Only Fencing Shown are CLF (Chain Link) and BWF (Barbed Wire). Entire outdoor storage area must be screened with 100% opacity.

Section 5.2.40.B
 Outside storage shall be enclosed and concealed by a solid fence or wall at least 6 feet in height or any combination of berming, shrubs, trees fencing or walls which will provide at maturity a minimum of 6 feet of height and 100% opaque screening for the area utilized for outside storage.

EDARP FILE NO.: PPR2332

DRAWN BY: O.E. WATTS DATE: 1-24-15 DWG. NO.: 18-5223-01 SURVEYED BY: DEV, ES, W, THRU 4-9-11	APPROVED BY: PROJ. NO.: DWG.:	REVISIONS 1-4-23 REVISIONS PER COUNTY COMMENTS DJW	OLIVER E. WATTS CONSULTING ENGINEER COLORADO SPRINGS	PROJECT AMENDED PLAT BARBARICK SUBDIVISION EL PASO COUNTY	SHEET NAME <h1 style="text-align: center;">SITE PLAN</h1>	SHEET NO. 1 OF 2
---	-------------------------------------	---	--	---	--	---------------------------

SHT. NO.  
2  
OF  
2

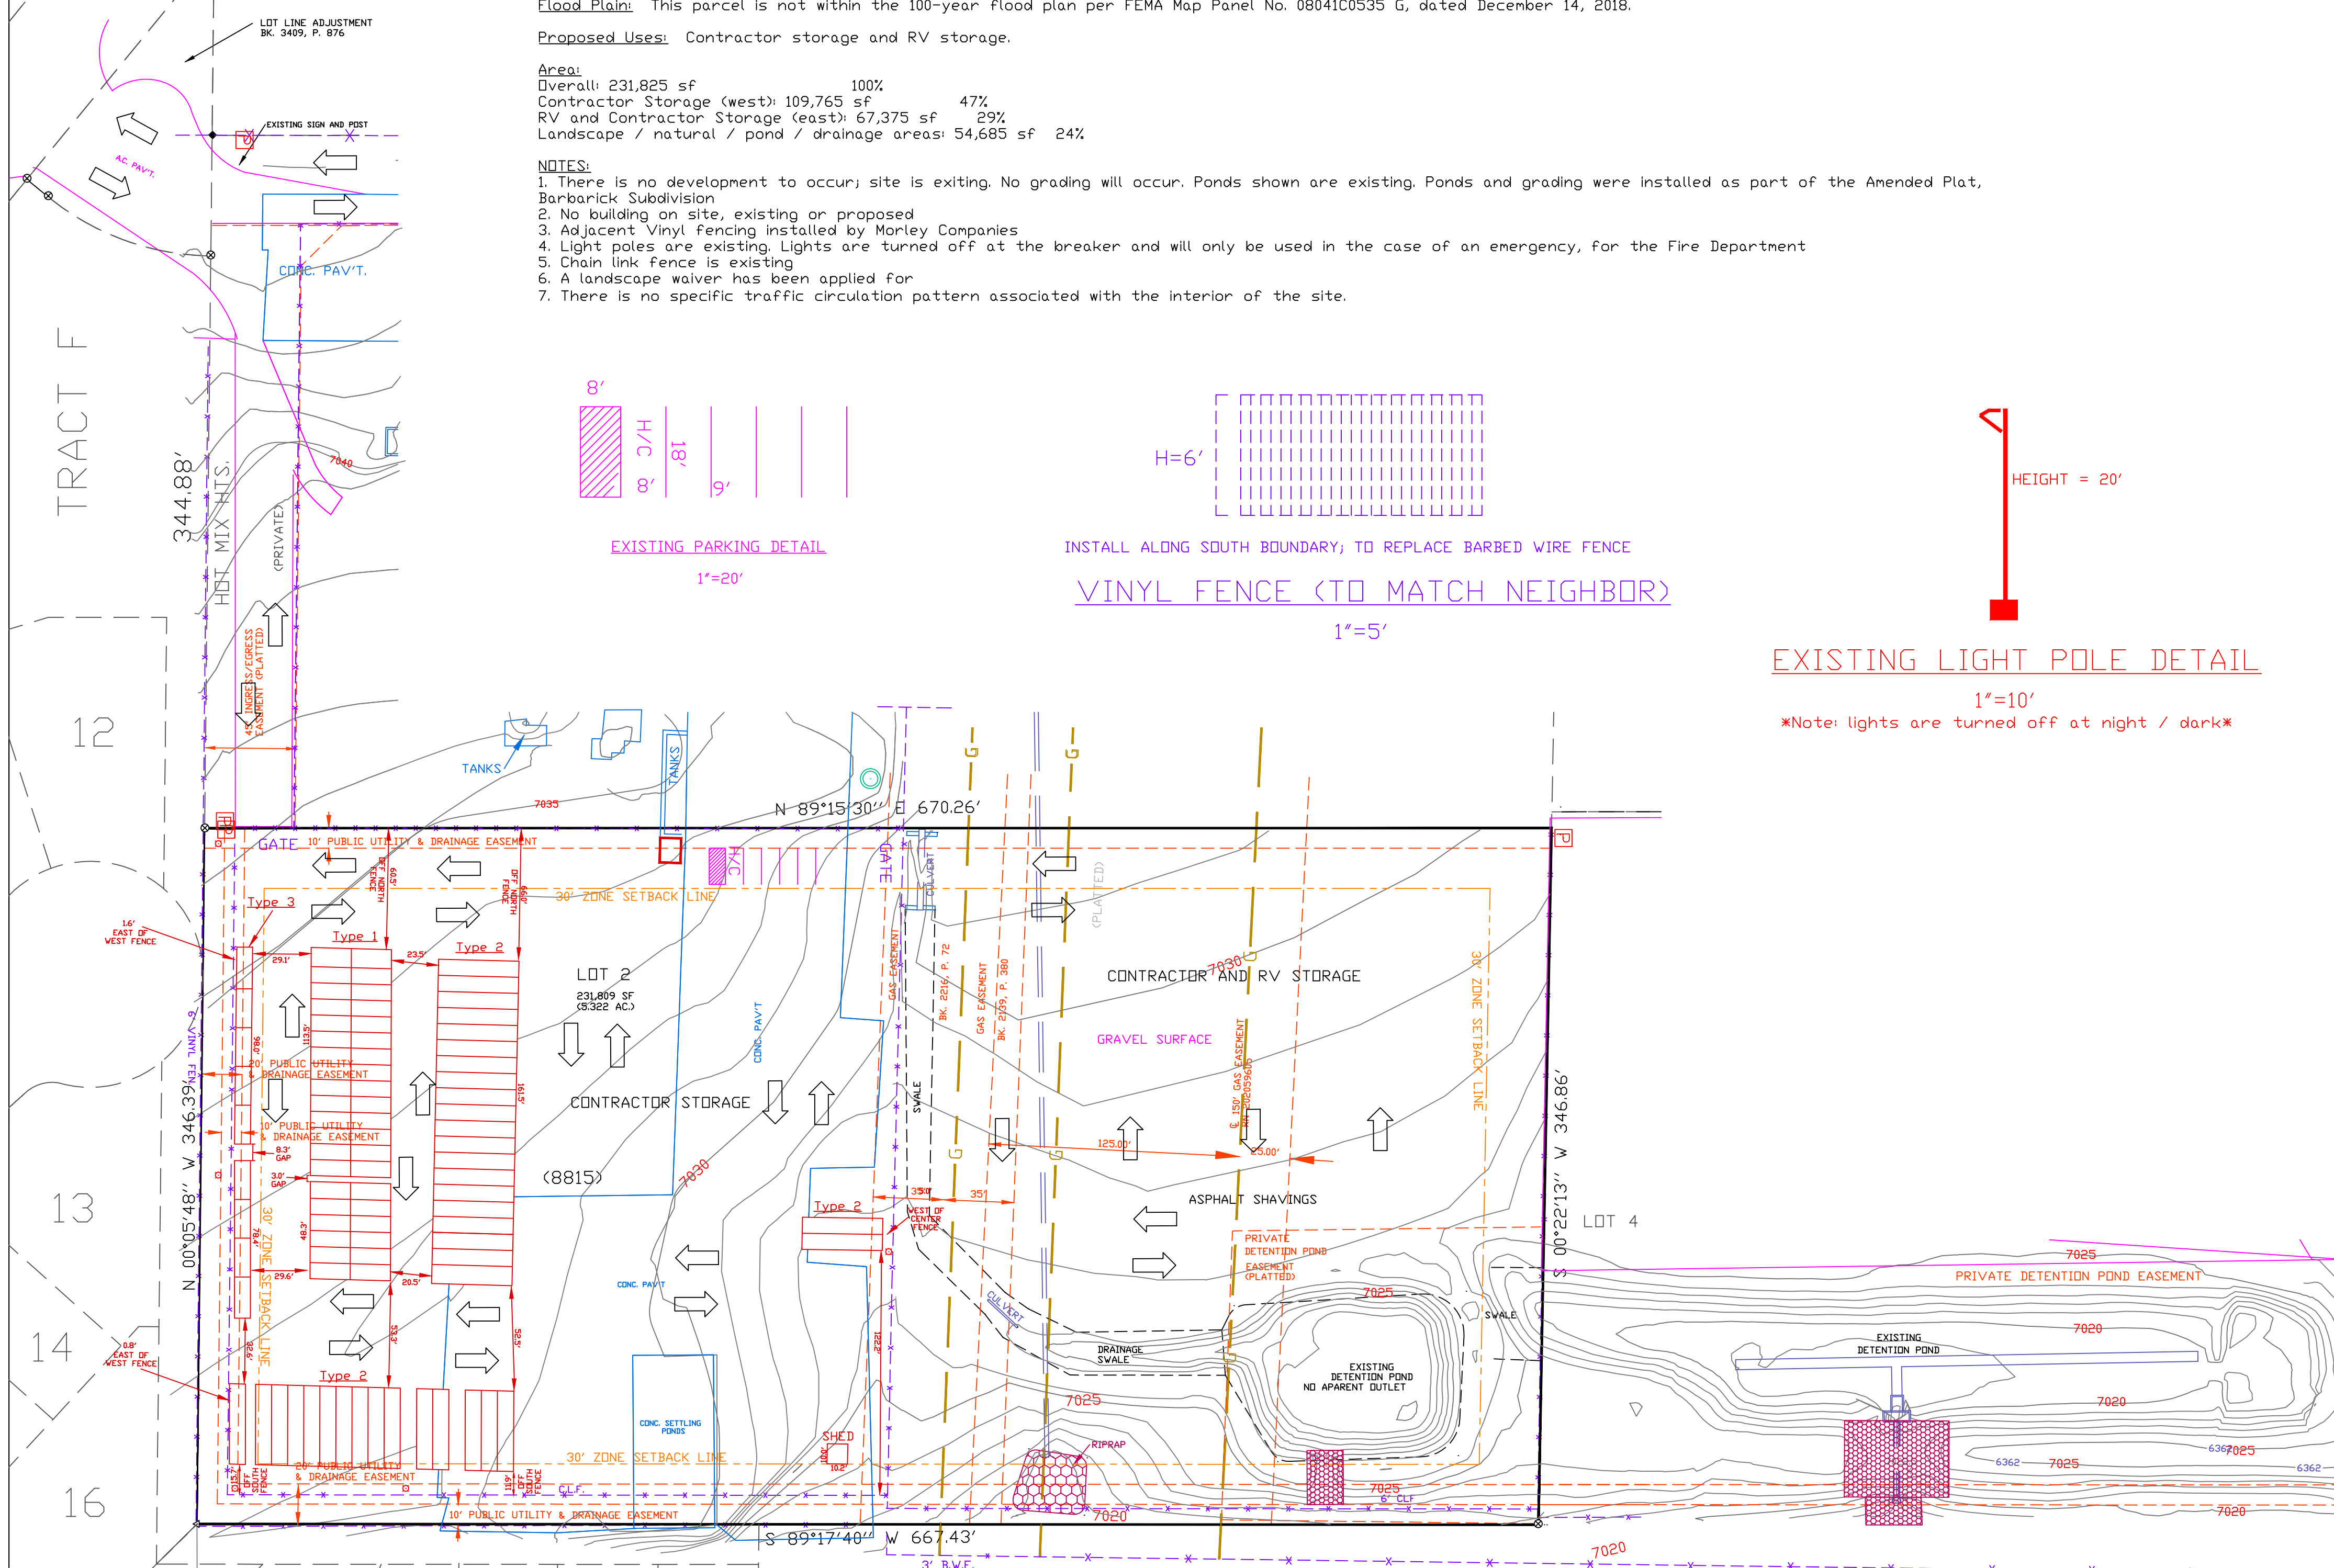
Letter of intent mentions vinyl fence. Please show location and description of this fence.

Use arrows to clearly show traffic circulation pattern within property.
